**KIRKLEES METROPOLITAN COUNCIL
INVESTMENT & REGENERATION SERVICE**

Reference No:	2025/62/91857/W
Site Address:	1, Bowness Drive, Dalton, Huddersfield, HD5 9PY
Description:	Erection of single storey side extension and front dormer
Recommending Officer:	Joshua Merriman

HOUSEHOLDER DELEGATED REPORT

Application Number	2025/91857
Location	1, Bowness Drive, Dalton, Huddersfield, HD5 9PY.
Proposal	Erection of single storey side extension and front dormer.
Publicity end date	05/12/2025 – The application was readvertised as a result of the single storey front extension being omitted and a new proposed single storey side extension.
Number of representations received	7.
Kirklees Local Plan Allocation/Designation	The application site is located an area with history of swift nesting records, but is otherwise unallocated in the Kirklees Local Plan.
Extension to Time (EoT)	Yes – 09/12/2025
Recommendation	Conditional Full Permission

CLIENT	Mr Aleem		
ADDRESS	1 Bowness Drive, Dalton Huddersfield, HD5 9PY		
PROJECT	Single Storey Front Extension and Front Dormer		
DRAWING	Existing and Prop Layout and Elevations		
DRAWN	UH	DATE	Feb 25
		SCALE	1.100@A1
DWG No.	2529/02		
STATUS	PLANNING

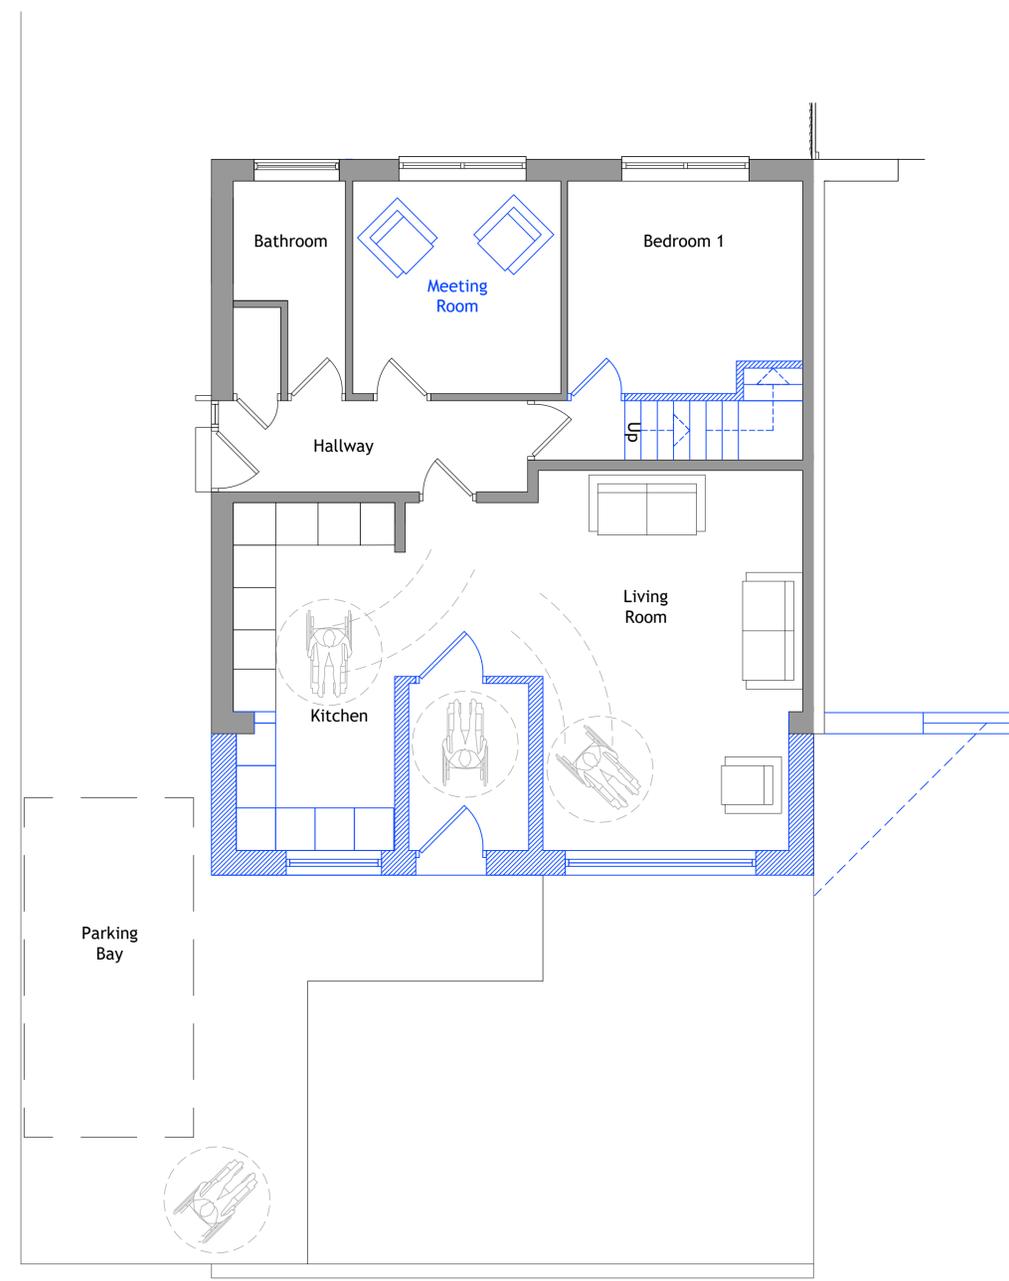
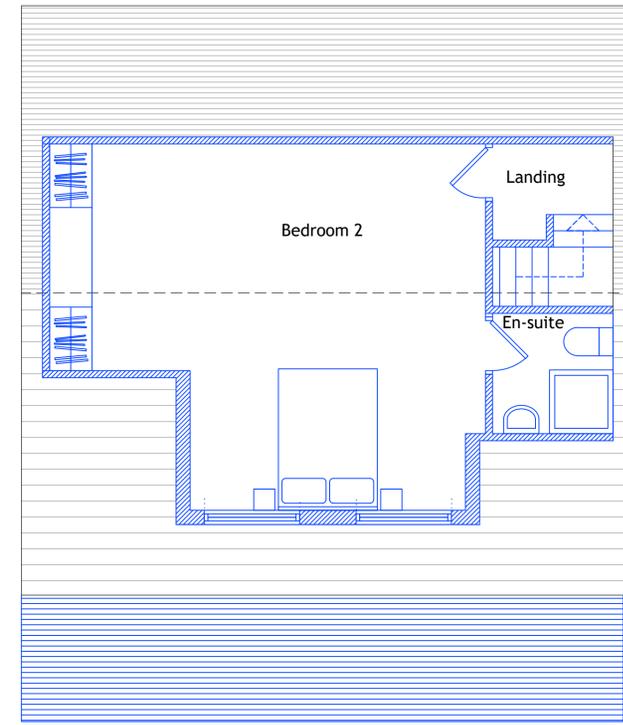
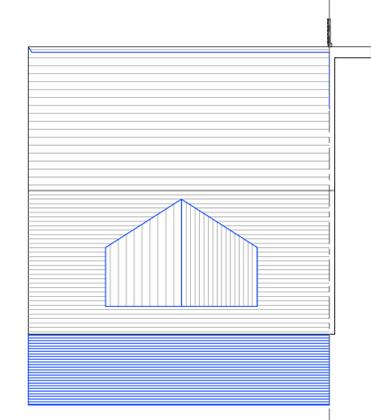
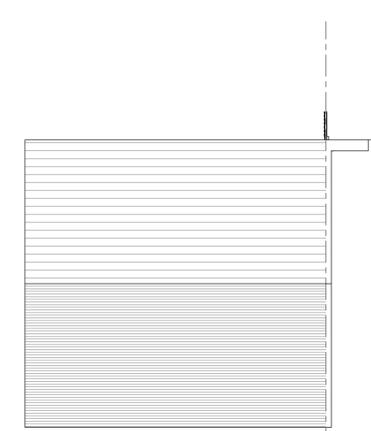
YES / NO	SUMMARY
Negotiations/Amendments during course of application	Yes	The initial proposal of a front extension was deemed unacceptable, therefore, a revised scheme for the development of a

side extension has instead been submitted which is considered acceptable.
Parish/Town Council comments sought	No	
Planning History	No	
Consultations required	No

It is noted that there are other objections that have been received regarding this application, however, they comment on the initially proposed development detailing a front extension rather than the amended plans showing a side extension. As a result, they are not considered relevant to the new plans and current application.

CLIENT	Mr Aleem		
ADDRESS	1 Bowness Drive, Dalton Huddersfield, HD5 9PY		
PROJECT	Single Storey Side Extension and Front Dormer		
DRAWING	Existing and Prop Layout and Elevations		
DRAWN	UH	DATE	Feb 25
		SCALE	1.100@A1
DWG No.	2529/04A		
STATUS	PLANNING

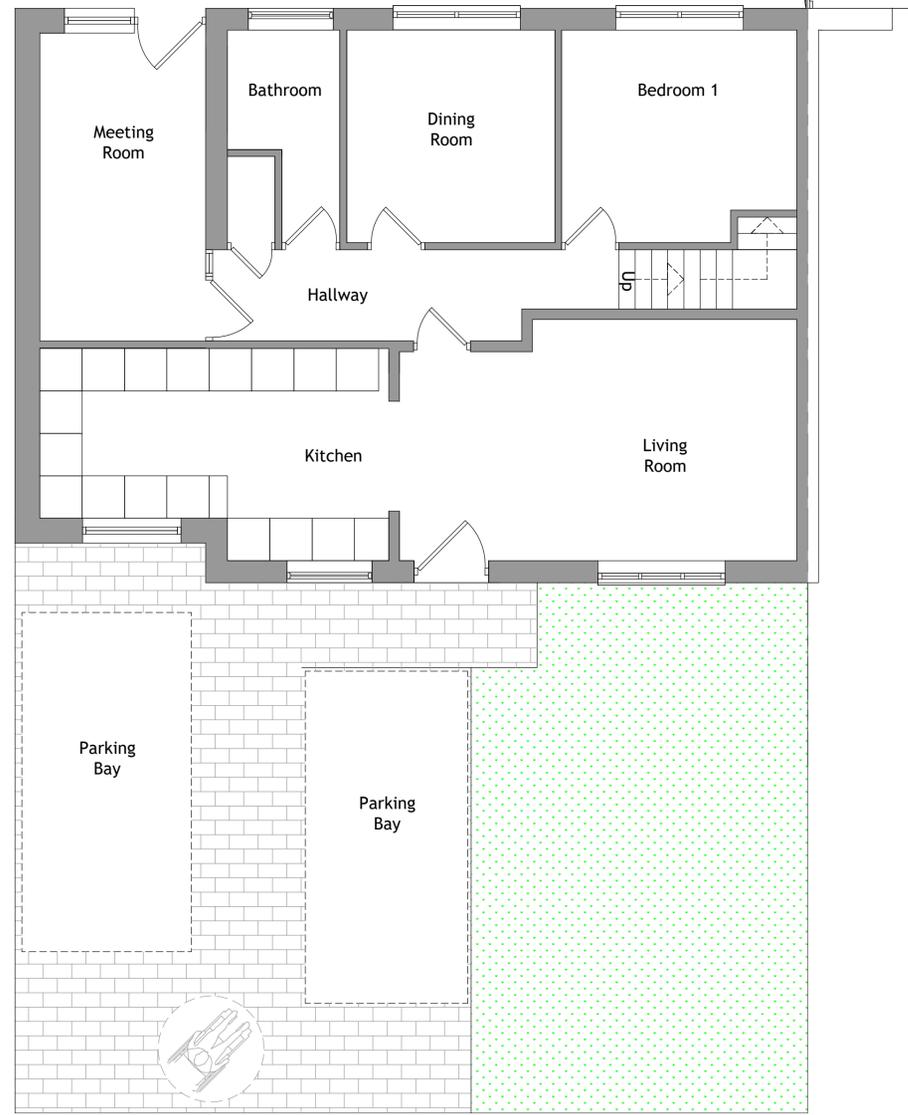
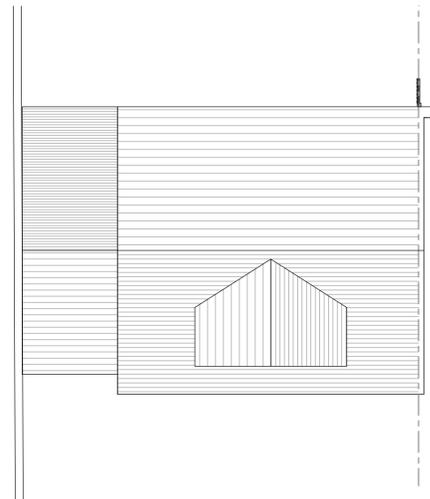
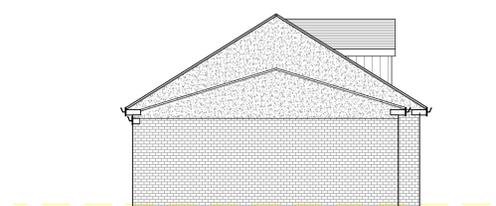
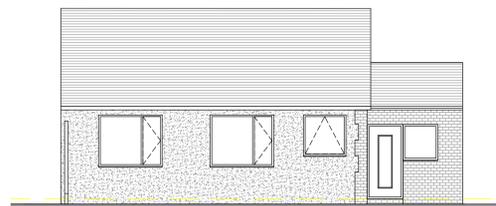
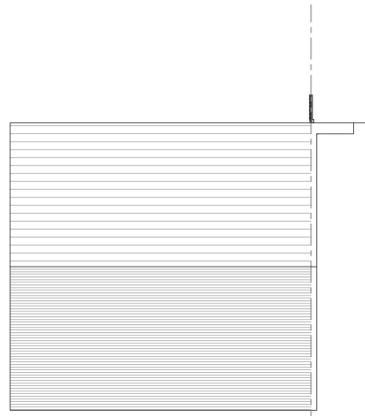
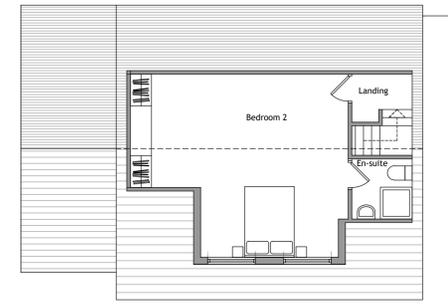
The proposed side extension will project 2.68m from the side elevation of the existing building, with a maximum height of 4m, eaves height of 2.59m, and a depth of 7.53m.

The proposed dormer will project a maximum of 3.1m from the original roof, with a maximum height of 1.87m, eaves height of 0.82m, and a width of 4.28m.

As mentioned, a condition has been added to the end of this report ensuring the dormer is faced in materials to match those used on the existing roof of the dwelling. This is because the dormer is the first of its type to be erected in the street scene, therefore, it wholly sympathetic materials must be ensured and no significant impact on the local character must also be ensured.

Summary of Representation	Officer response	Addressed ✓ / X / N/A
No Design & Access Statement has been submitted.	This is not required for an application of this nature.	✓
A 1m wide access is not retained at the side of the property.	The side extension has been designed in this way to meet the needs of a disabled user, and reducing the size of the development would cause the extension to fail to meet the needs of its user, therefore, it is considered that in this case forgoing a sizeable external access to the rear garden is acceptable. It is also noted that the side extension could be constructed under permitted development.	✓
What parking provision is made available at the property.	This is addressed in the 'Highway Safety' section of this report.	✓
The dormer is shown with a window facing NE, surely a SW elevation would be better.	This comment is noted, however as the dormer is a small addition that is well designed to the front of the property, it is considered visually acceptable. In addition, there are no concerns to impact on residential	✓

3. The external walls and roofing materials of the side extension hereby approved shall in all respects match those used in the construction of the existing building.

4. The face and cheeks of the front dormer hereby approved shall be faced in vertically hung tiles which shall in all respects match those used in the construction of the existing building. The dormer shall thereafter be retained with this finish.
